Subject: SHL23-011 Shoreline Exemption Permit, Pump Station 4 – 2239 60<sup>th</sup> Ave SE.

This is a written response to the review comments provided by the Community Planning and Development Department regarding the application for the Shoreline Exemption Permit, SHL23-011, for Pump Station 4 located at 2239 60<sup>th</sup> Ave SE .

PUMP STATION 4 -
PLAN

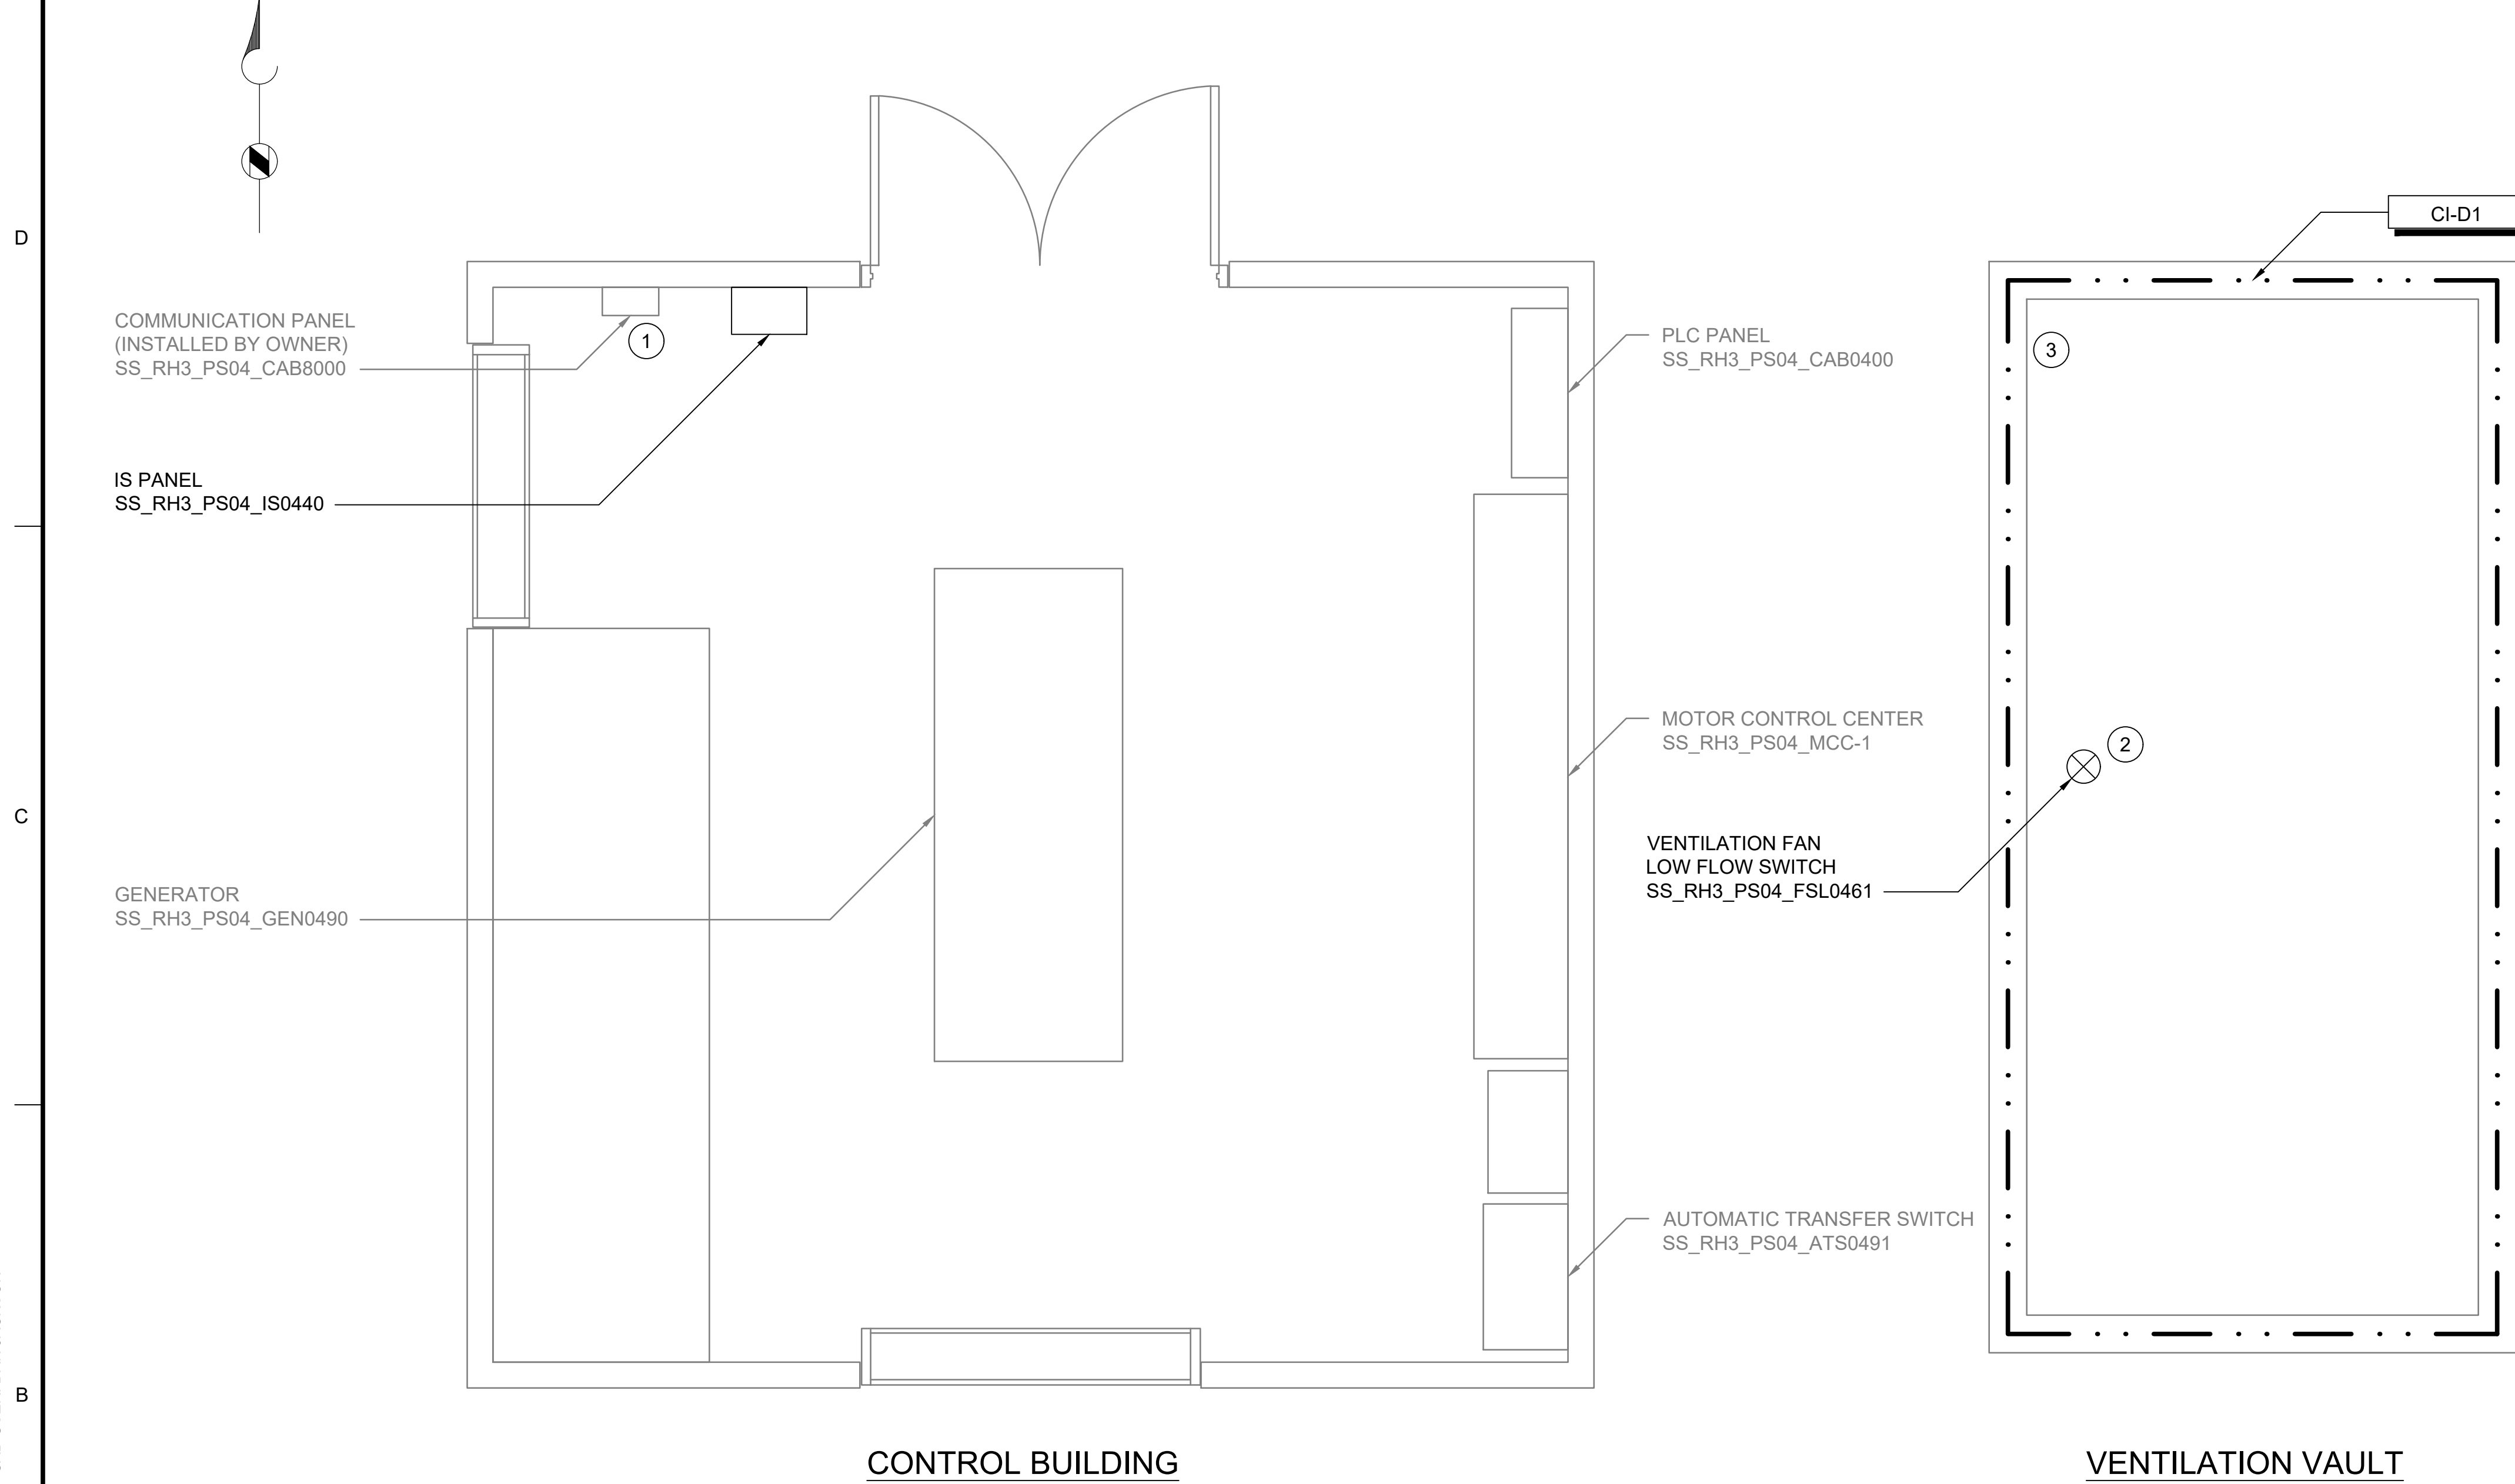
- a. Provide address of all pump stations on plans

**Response:** *The address for the pump station has been added to Development Plan, Instrumentation Drawing page 1. The address was also included in the aerial photo of the pump station.*
